City of Albuquerque
Planning Department
Inter-Office Memorandum

SUBJECT: Project # 1008086

On January 21, 2010, the Environmental Planning Commission approved Project # 1008086 09EPC-40068, a Site Development Plan for Building Permit, for all or a portion of Lots 6, 27 & 28, Block 10, Tract 2, North Albuquerque Acres, Unit 3, located on Paseo del Norte & Holly Avenue, between Wyoming Boulevard and Louisiana Boulevard, containing approximately 1.84 acres.

DEVELOPMENT REVIEW BOARD – SPEED MEMO

HC Ramp Details

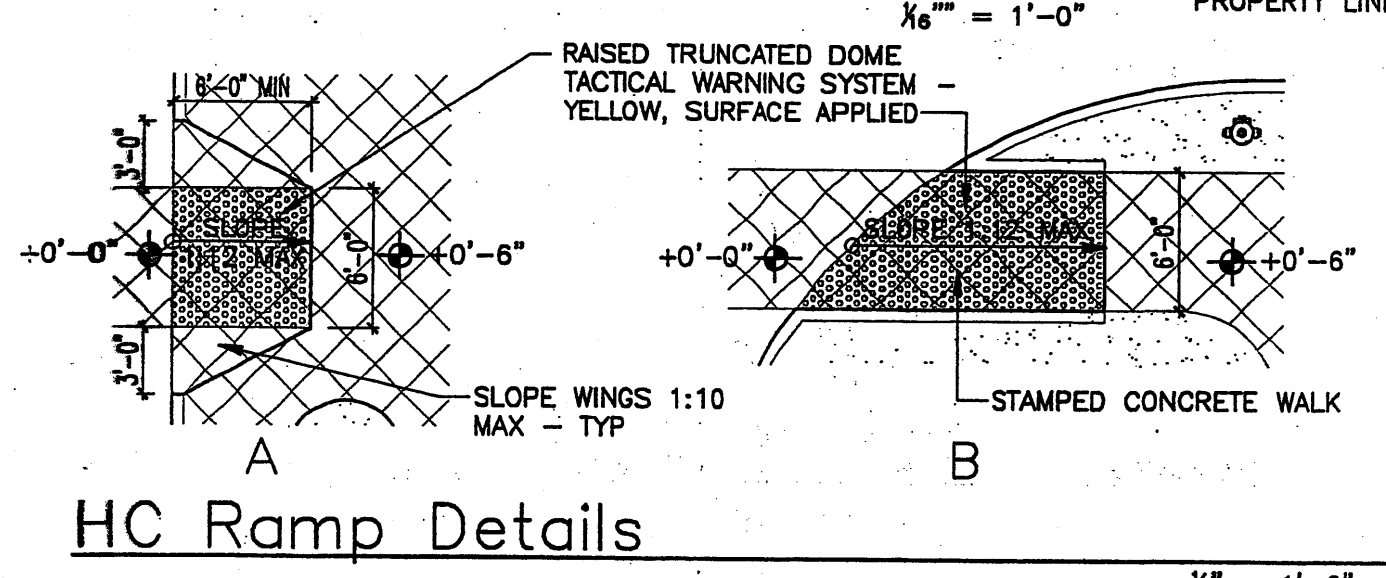
Show all ramps and provide details.

All wheelchair ramps located within the public right of way must have truncated domes.

Site Plan

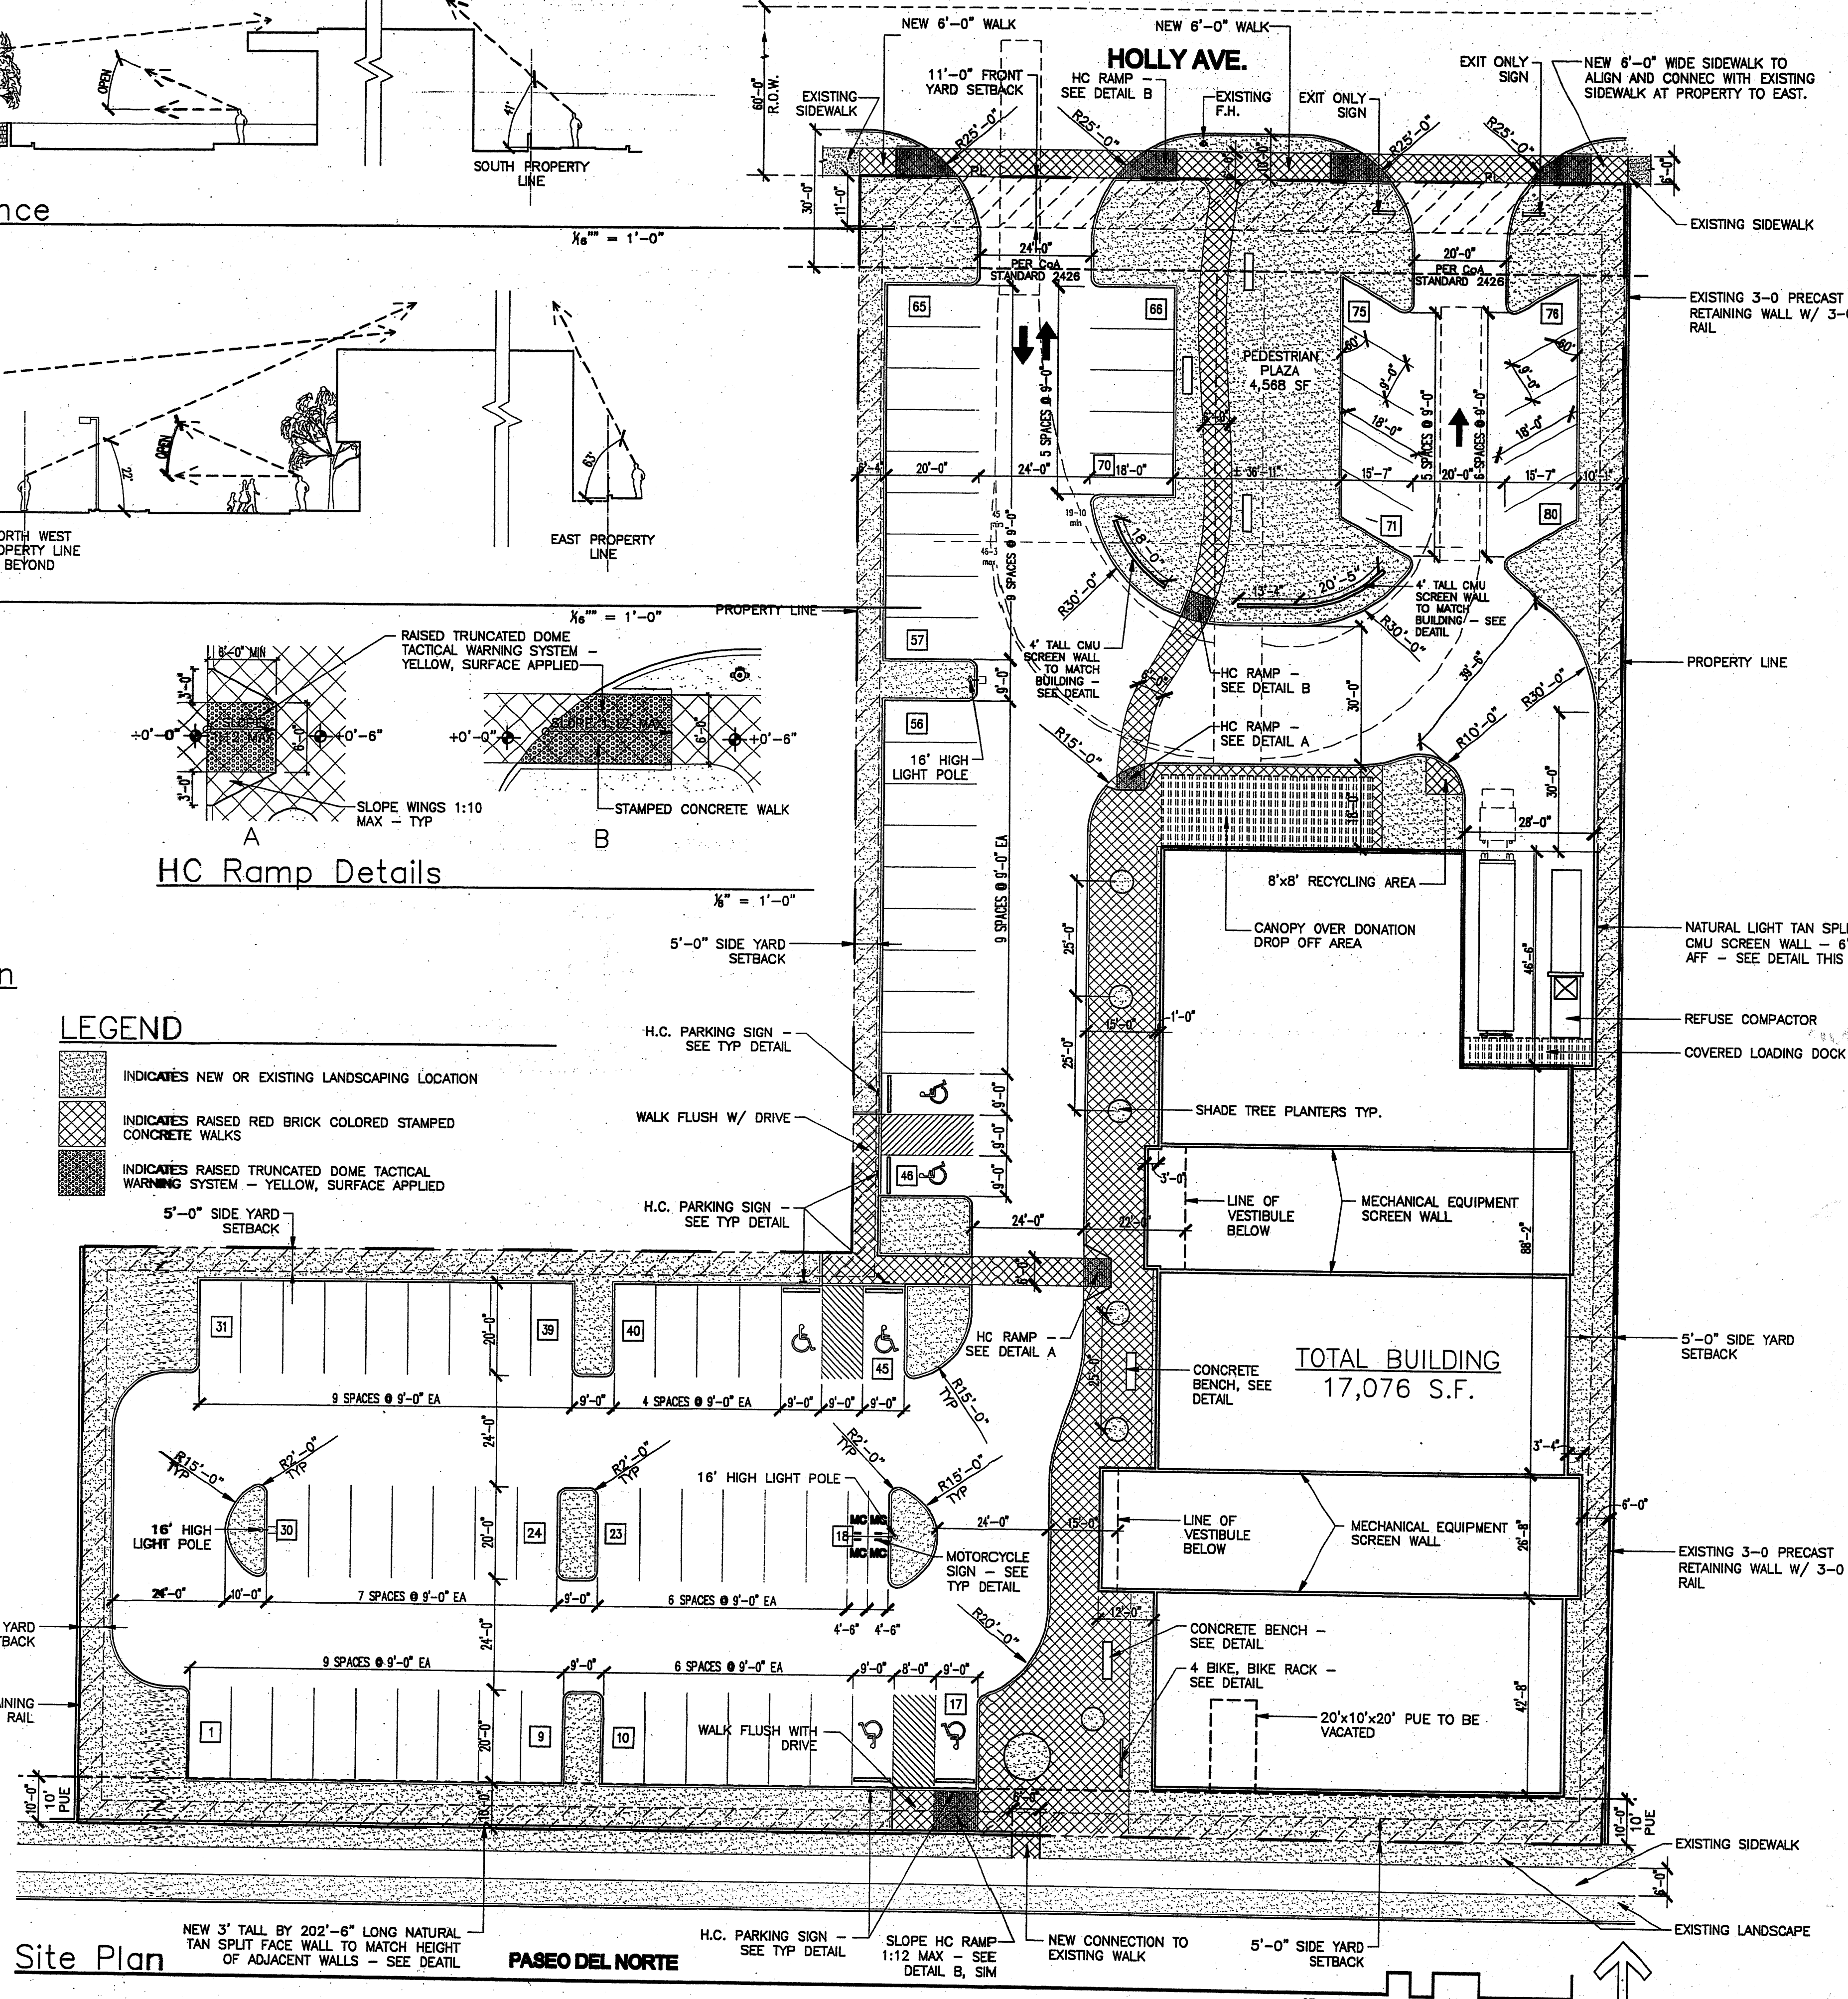
The landscape calculations comply with Section 14-16-3-10 (E)(1) of the Zoning Code. However, the total landscape provided (19,904) appears to be in error. Adding the total bed provided (16,681 s.f.) to the total Paseo del Norte ROW bed provided (3,461 s.fl) makes a total of 20,142 s.f.

Provide an exhibit showing the location of sidewalk and defining the distance from face of curb to the property line. Right of way dedication may be required.

Define the height of the existing retaining wall and rail (shown along eastern property line).

Define the ADA accessible pathway from the handicapped parking spaces. Show all ramps and provide details.

CONCEPTUAL WATER AND SEWER PLAN

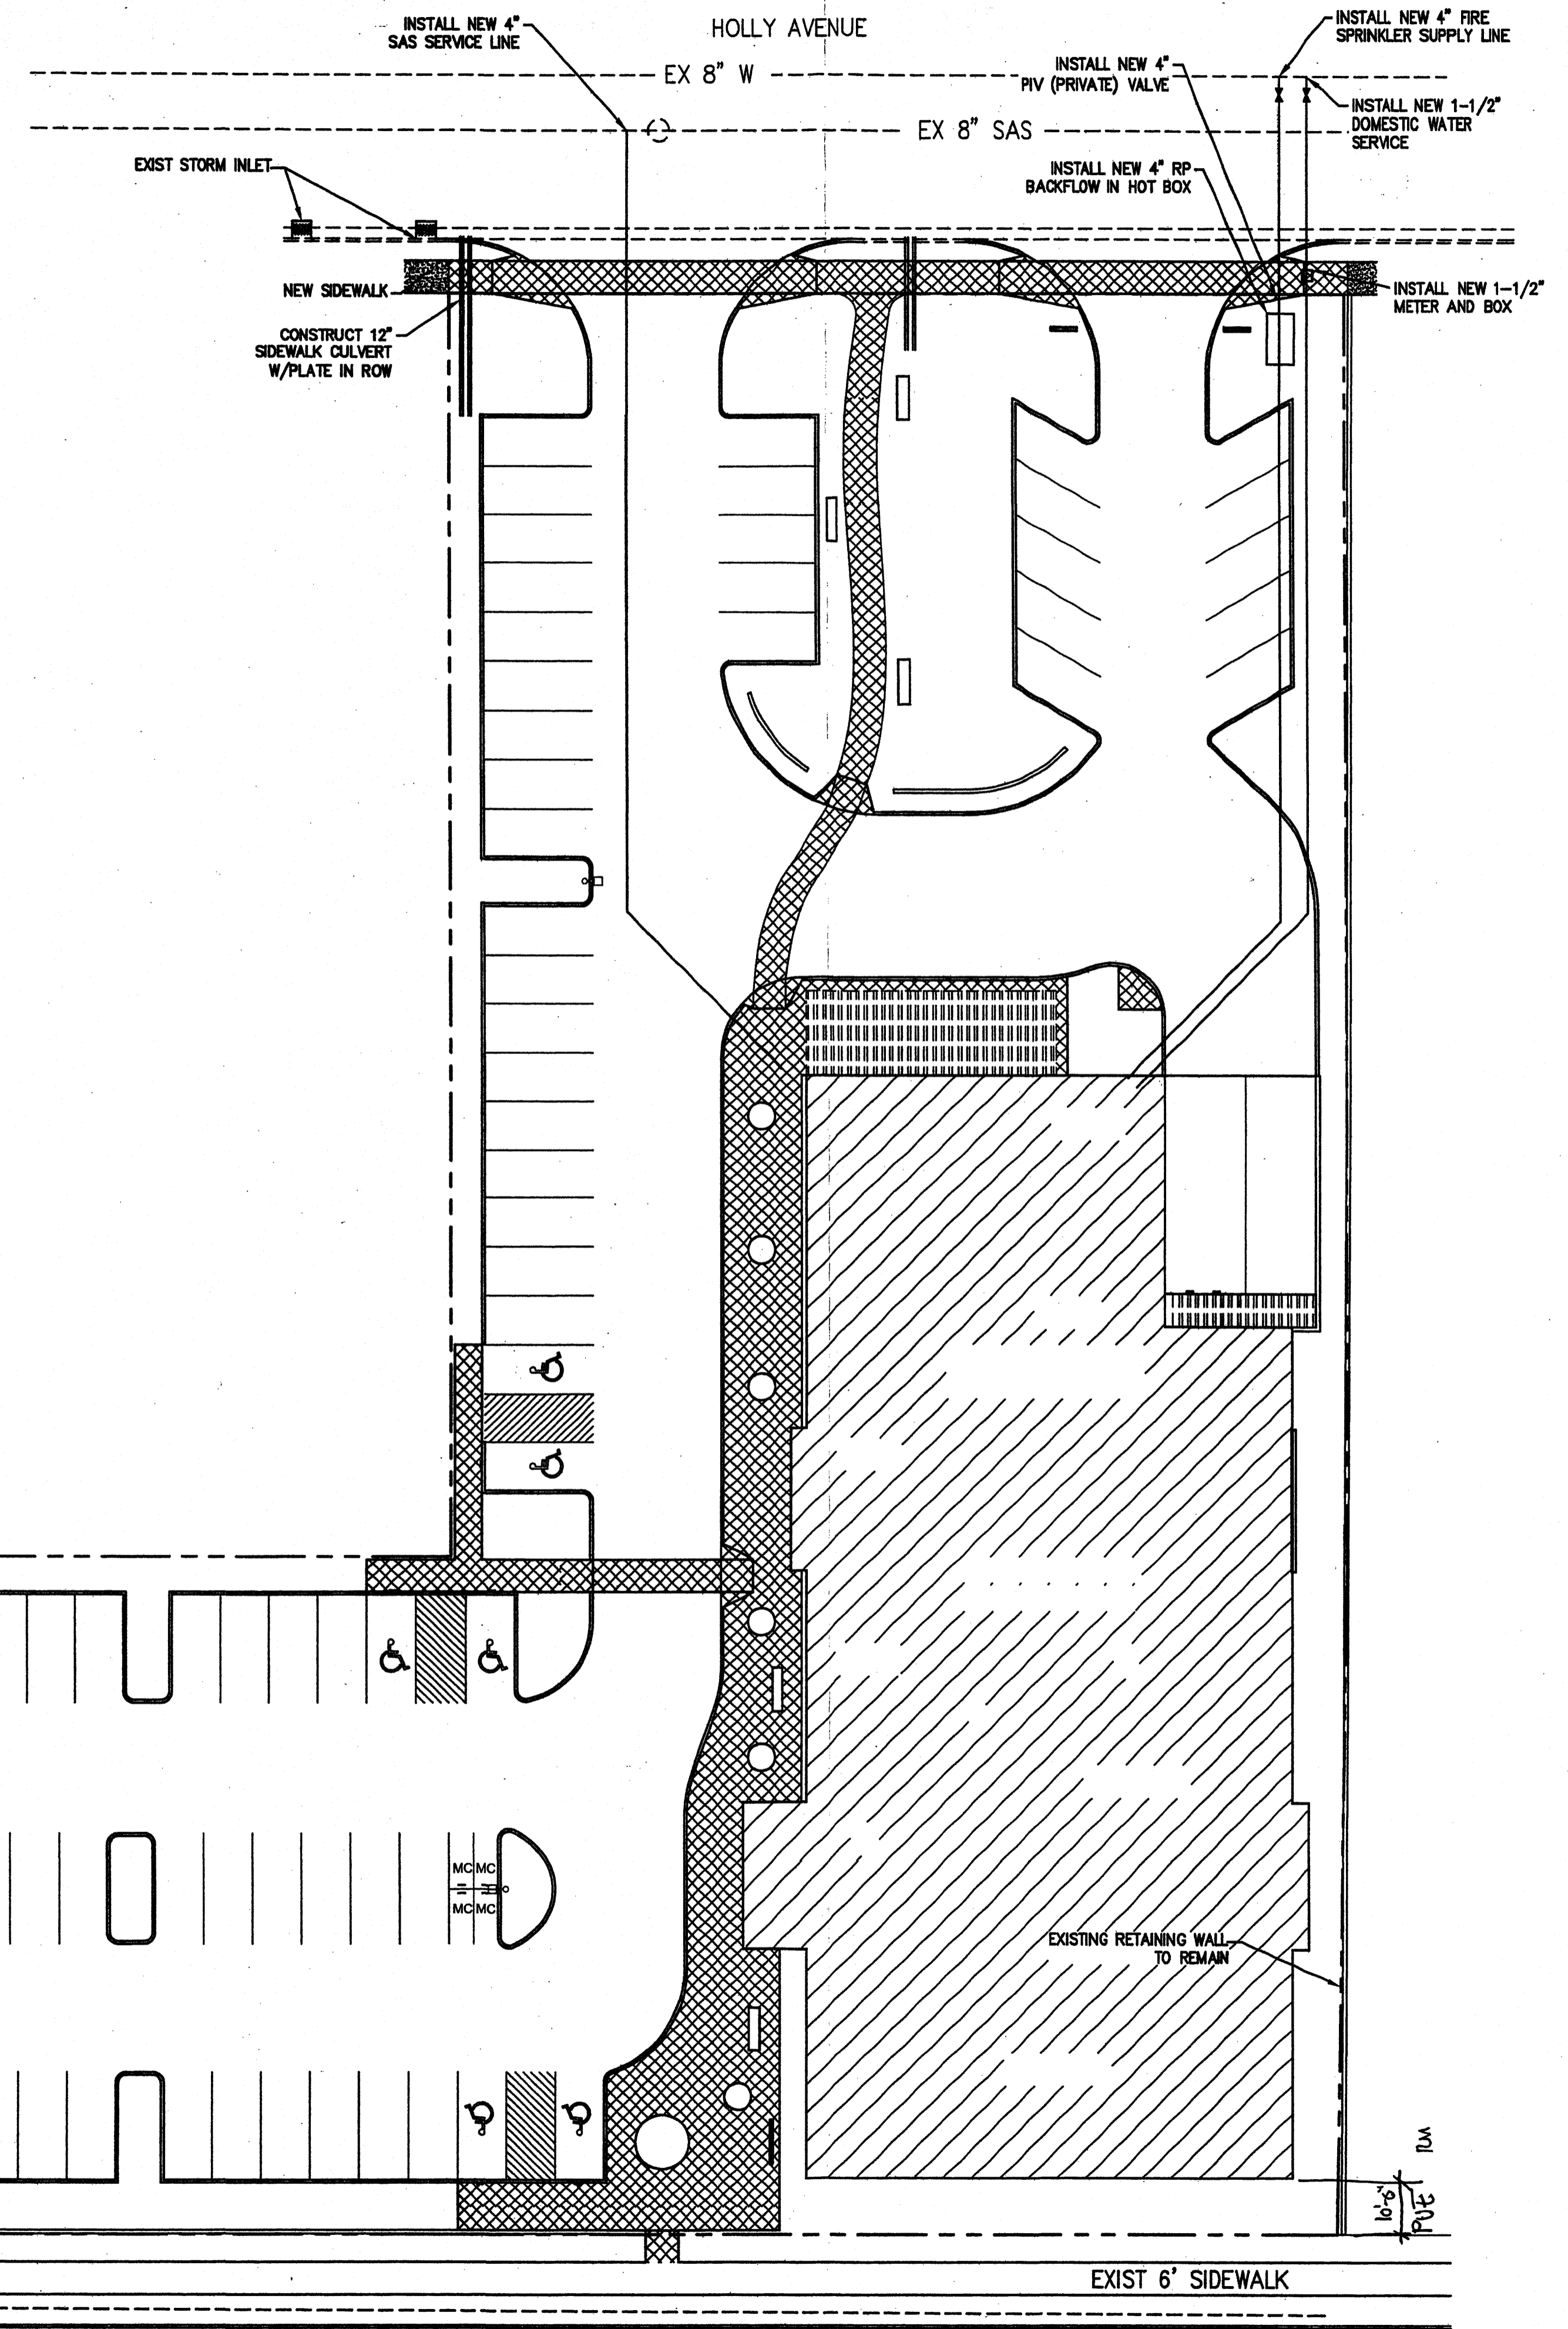
The public utility easement is shown on the site development plan for building permit, but not on the site plan utility sheet (conceptual water and sewer plan).
